## Application for a Non-Material Amendment Following a Grant of Planning Permission

Single storey extension to rear and sliding doors to side with steps.

DM/23/03261/FPA

Revised windows incorporaing brick piers

Rev A: - windows revised 02/24  
 All dimensions to be checked on site

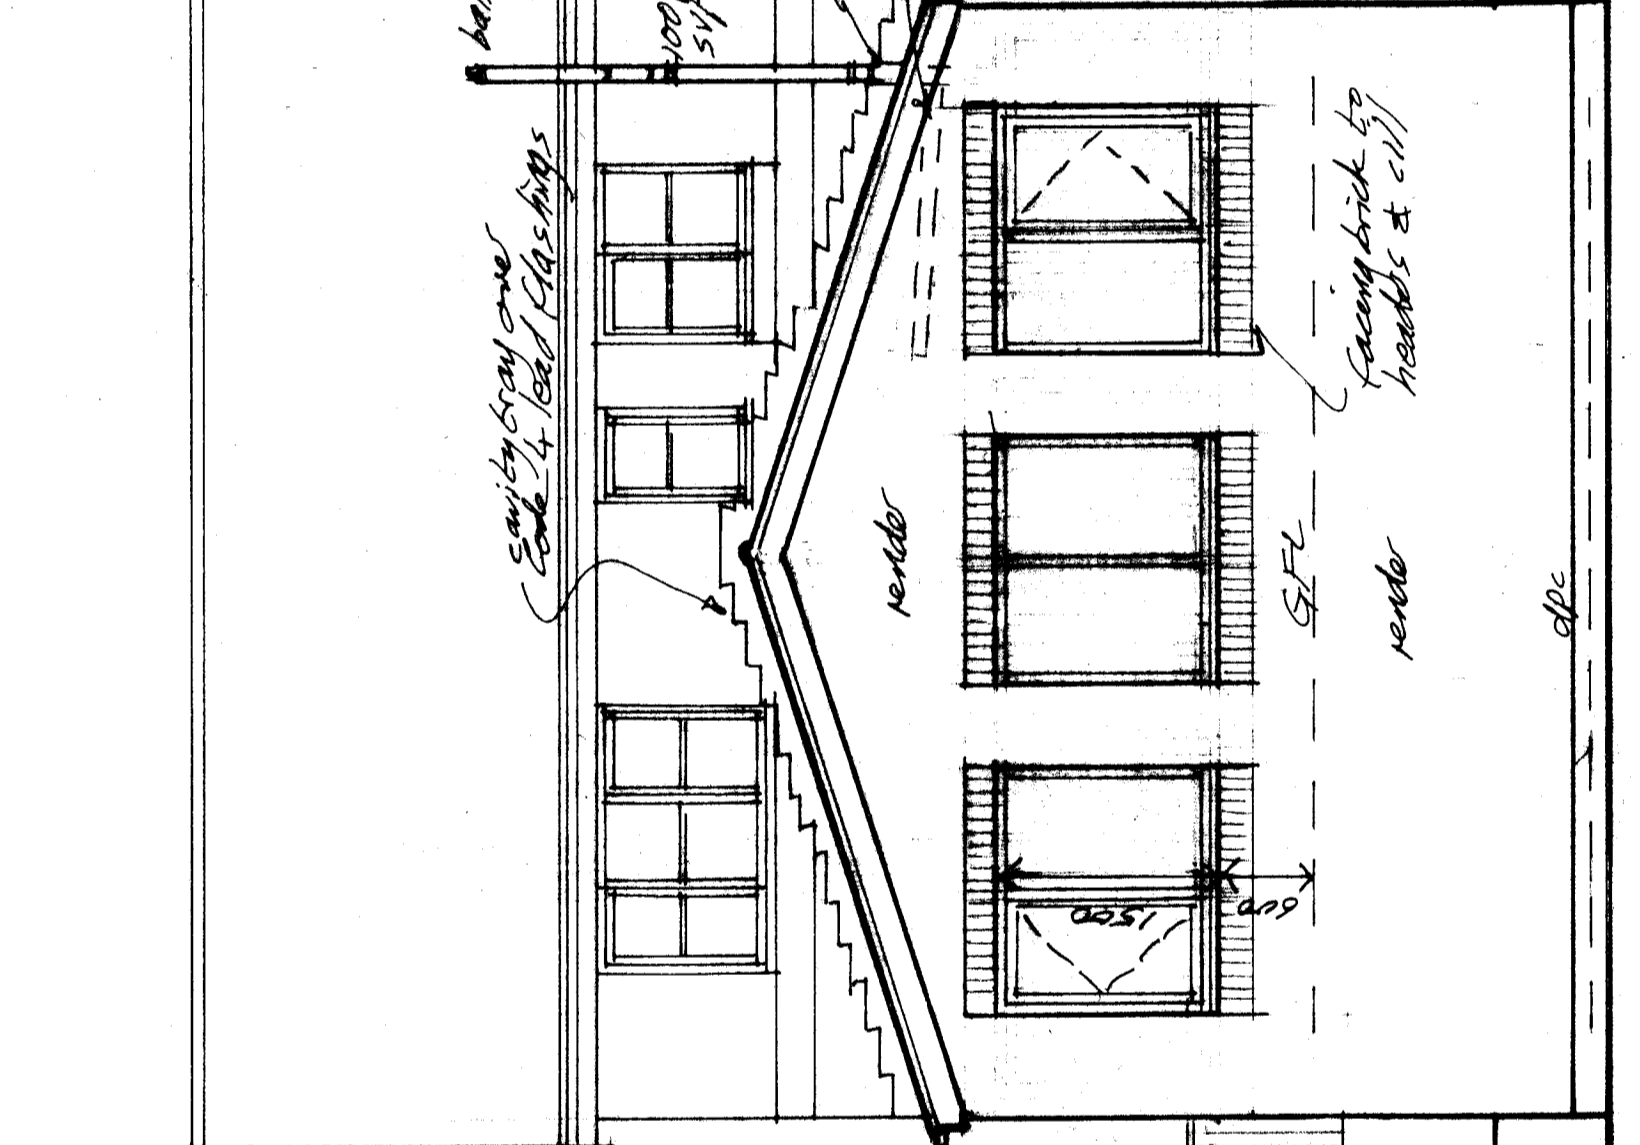
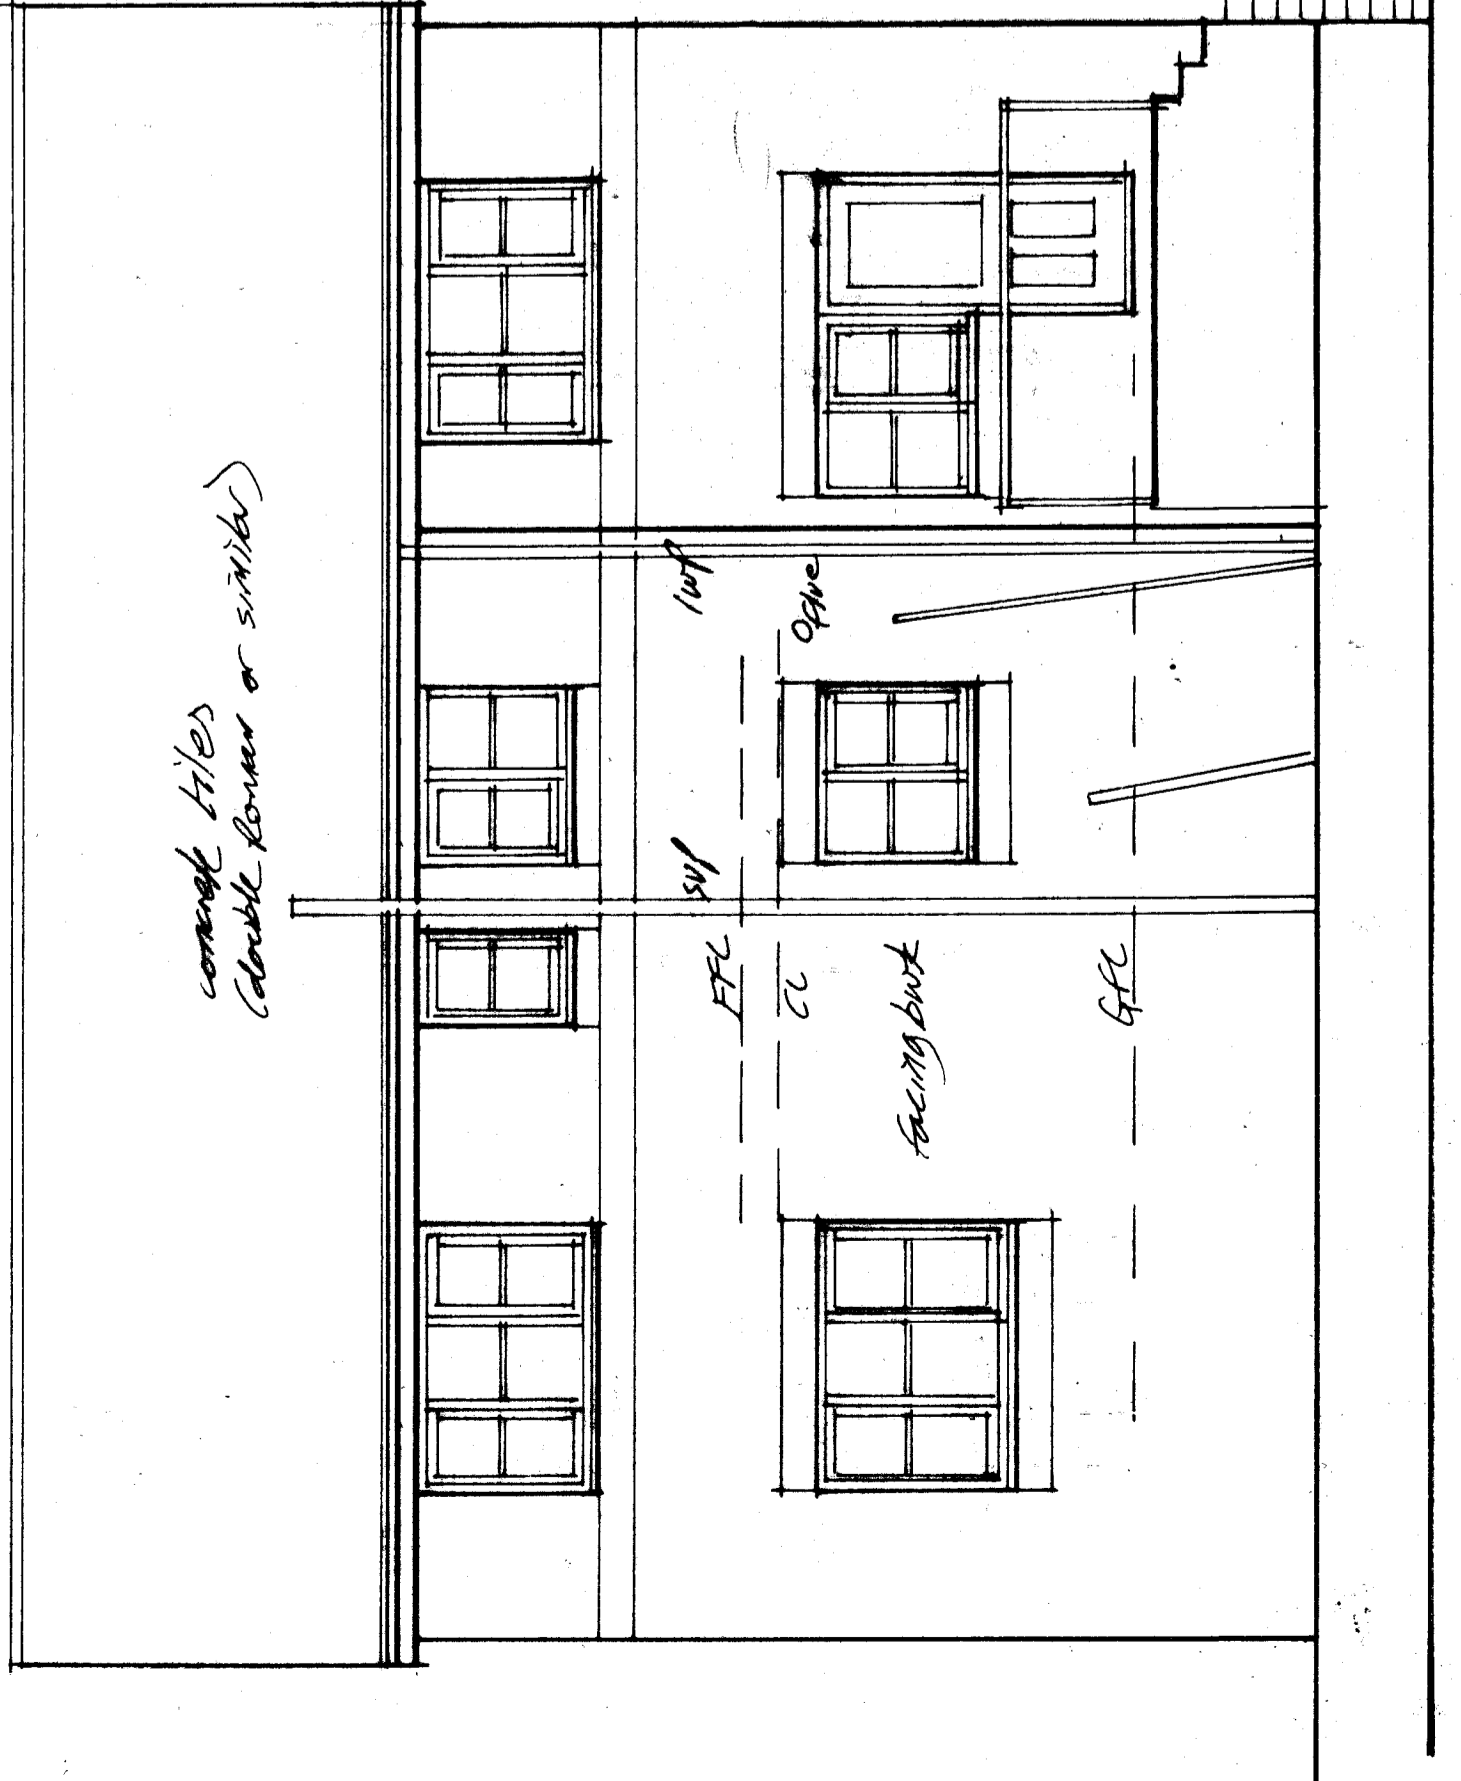
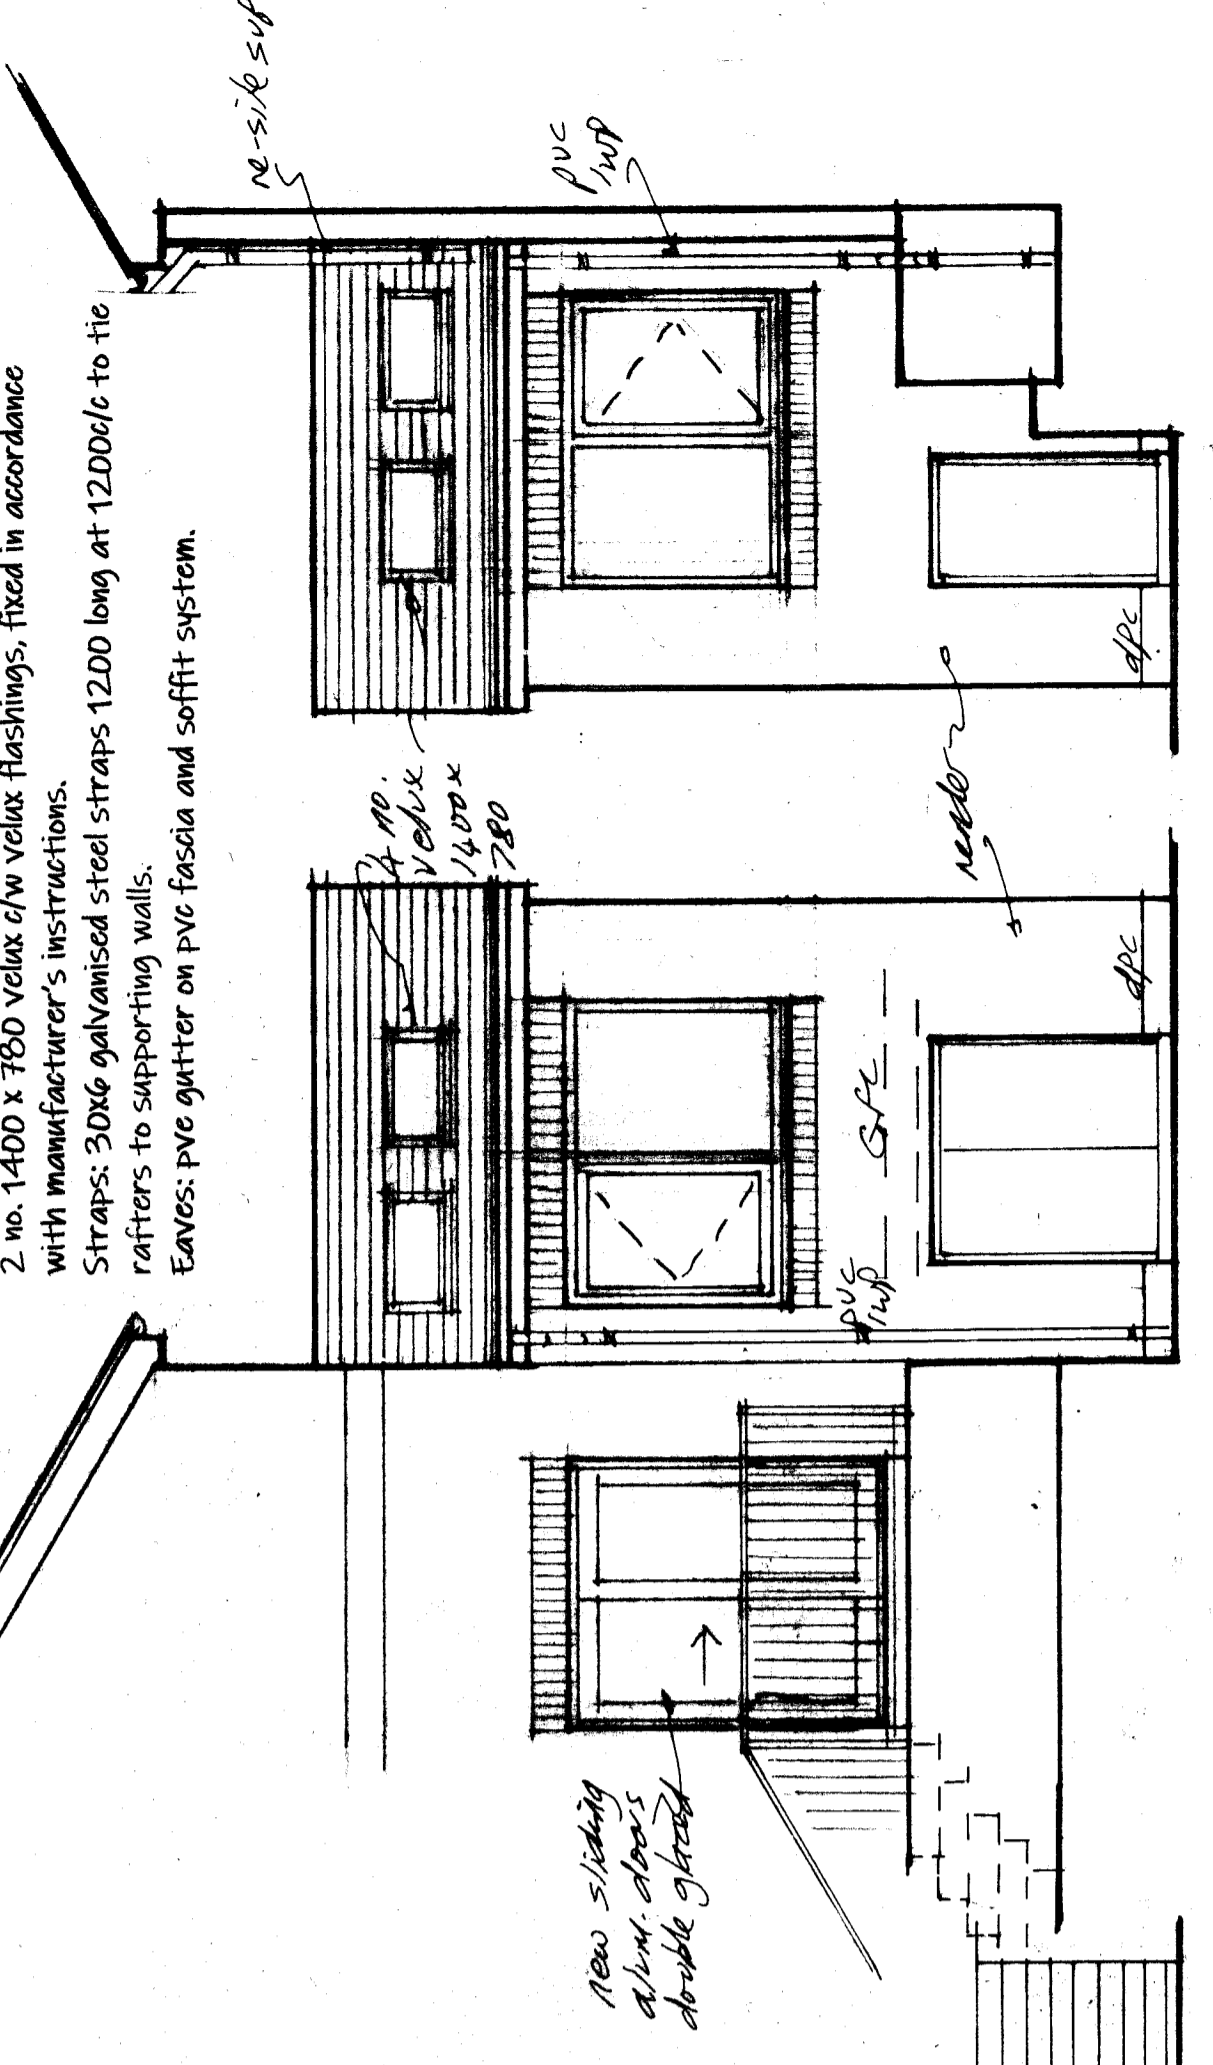
Simplify construction

OT/1 rev A
